# **OXFORDSHIRE COUNTY COUNCIL'S RESPONSE TO CONSULTATION ON THE FOLLOWING DEVELOPMENT PROPOSAL**

**Application no:** 23/00667/REM

**Proposal:** Reserved matters application, pursuant to the outline planning permission granted under reference 21/03644/OUT for the erection of up to 49 dwellings

**Location:** OS Parcel 6372 South East Of Milestone Farm, Broughton Road, Banbury

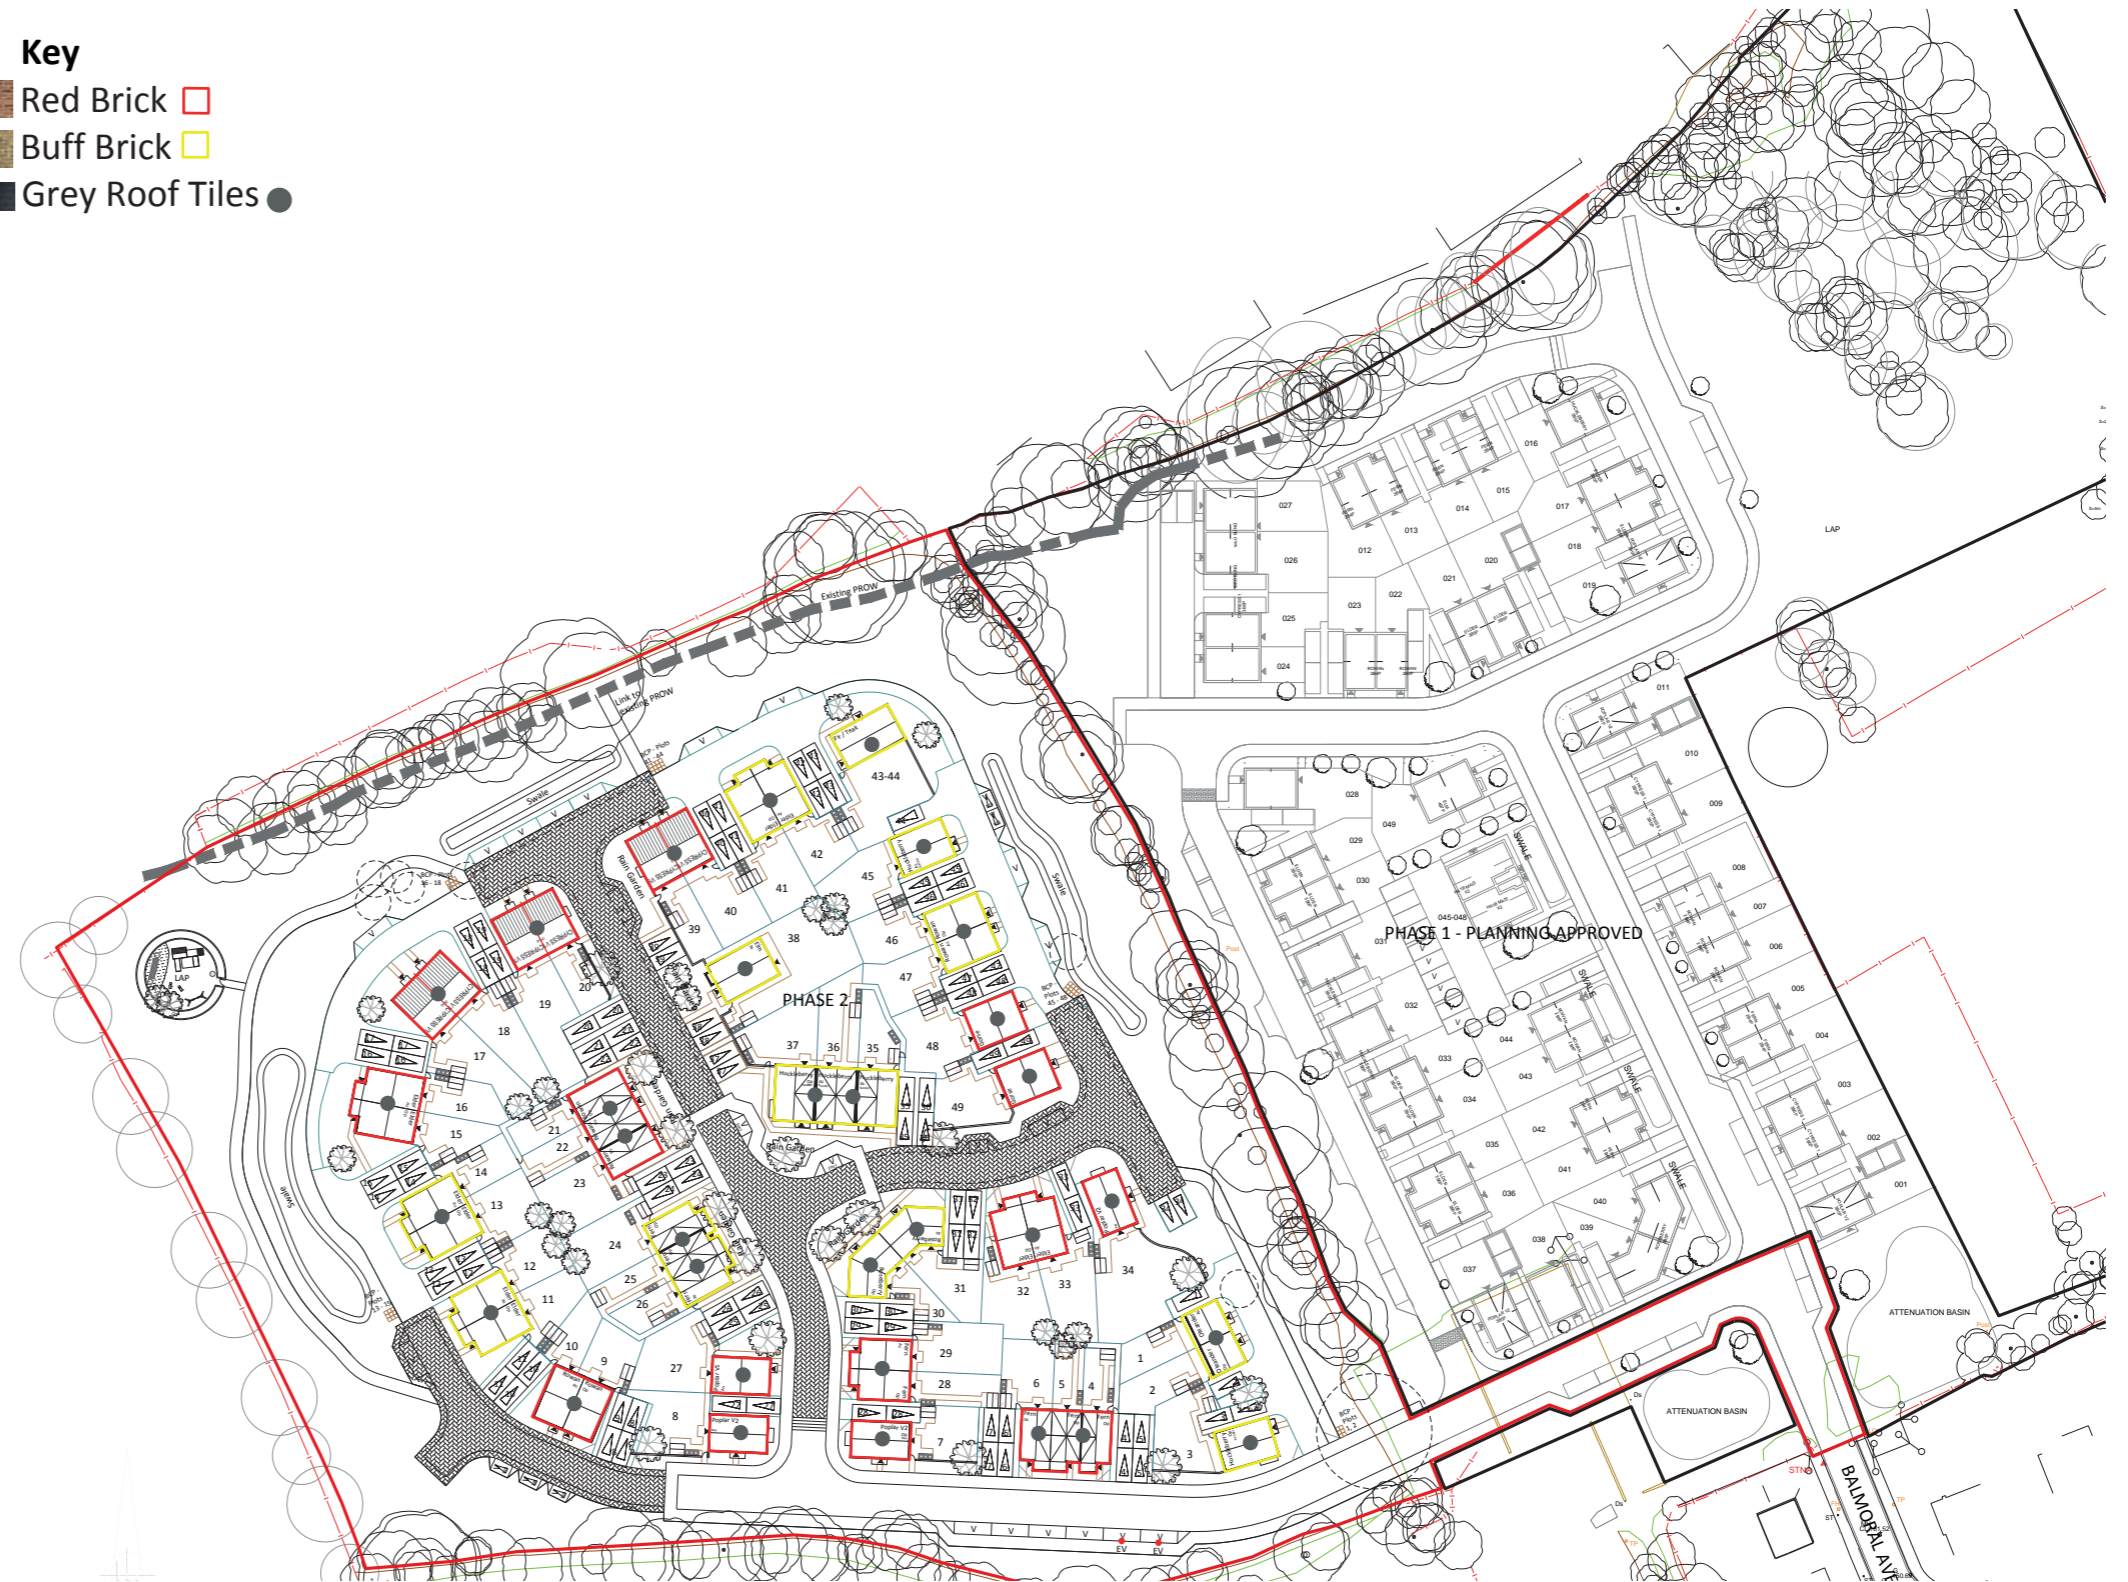
Sheds accommodating only two cycles, as stated in the D&AS, are insufficient for house sizes of two bedrooms and above.
